Arun District Council - Development
Control
MALTRAVERS ROAD,
LITTLEHAMPTON, BN17 5LF

Reference: PA-0000287/02
Customer reference: BE/15/26/PL
27 April 2026

New Docs - Erection of a 3-storey building comprising of under-croft car parking and bicycle store, 2 floors of 4 No self-contained flats on each (8 No flats in total) with pedestrian access formed onto Ash Grove. This application is in CIL Zone 4 (Zero Rated) as flats

Land Est of Heath Place, Bersted, PO22 9SL.

PROPOSED Lower Ground Floor Plan

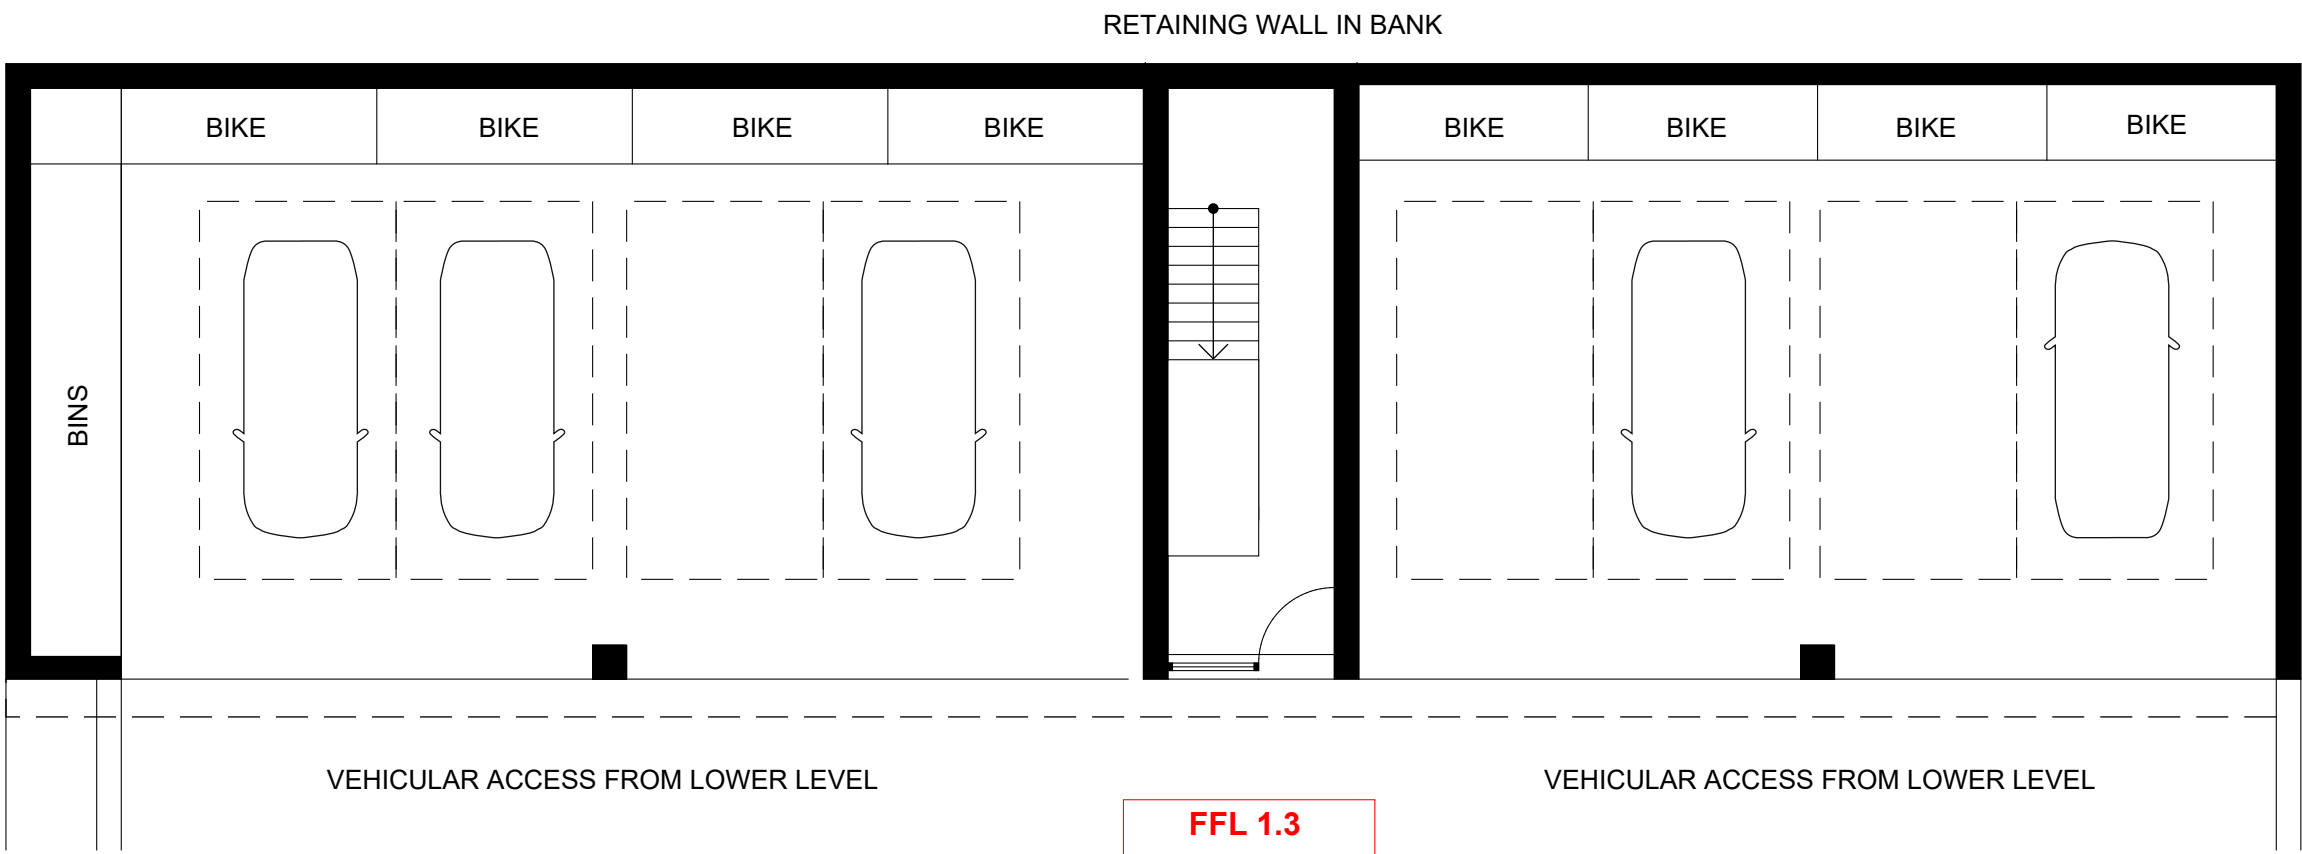
The use of under croft car parking at ground floor level has been proposed at other sites within the Aldingbourne Rife catchment area. Our local position is that, while in some cases they allow water to flow freely and will therefore not be classed as voids, they do not remove the need for floodplain compensation entirely. Therefore, loss of floodplain area to accommodate large supporting pillars/posts for these structures, should still be adequately compensated.

We acknowledge that the submitted proposals involve lowering the car parking area, which should result in an overall increase of floodplain capacity. However, sufficient detail or drawings of the compensatory area have not been provided to show the volume lost against the volume gained, and evidence that this shall be level-for-level. This design will need to be conditioned as part of any planning permission for the development.
